MECKLENBURG COUNTY
Park and Recreation Department

MEMORANDUM

DATE: February 22, 2024

RE: Rezoning Petition #2024-003
PID# 03721401

SHEET NUMBER  
**RZ-1**

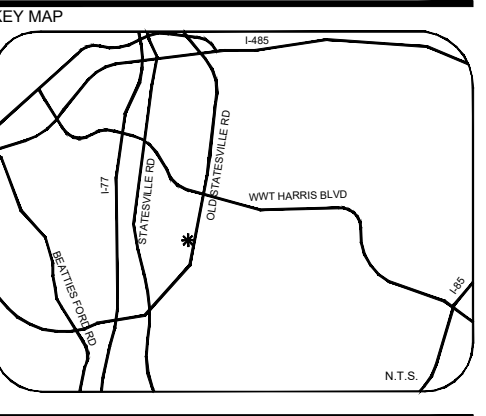
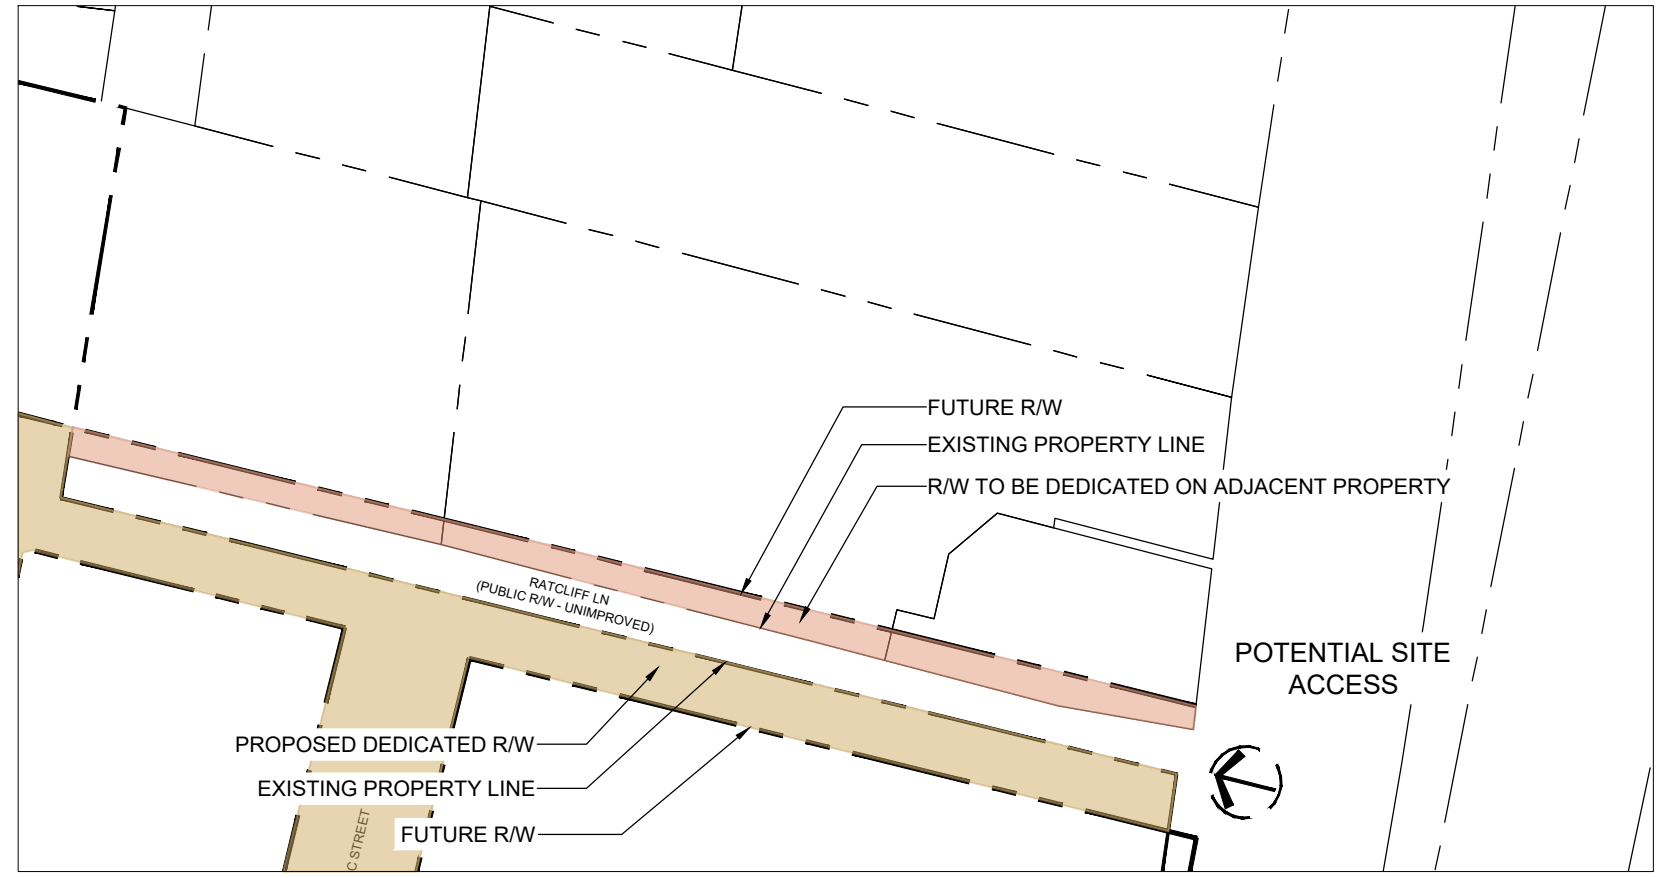
This parcel is a proposed urban trail on the Mecklenburg County Greenway Master Plan. Please provide pedestrian and bicycle accommodations along the frontage of Hwy 115.
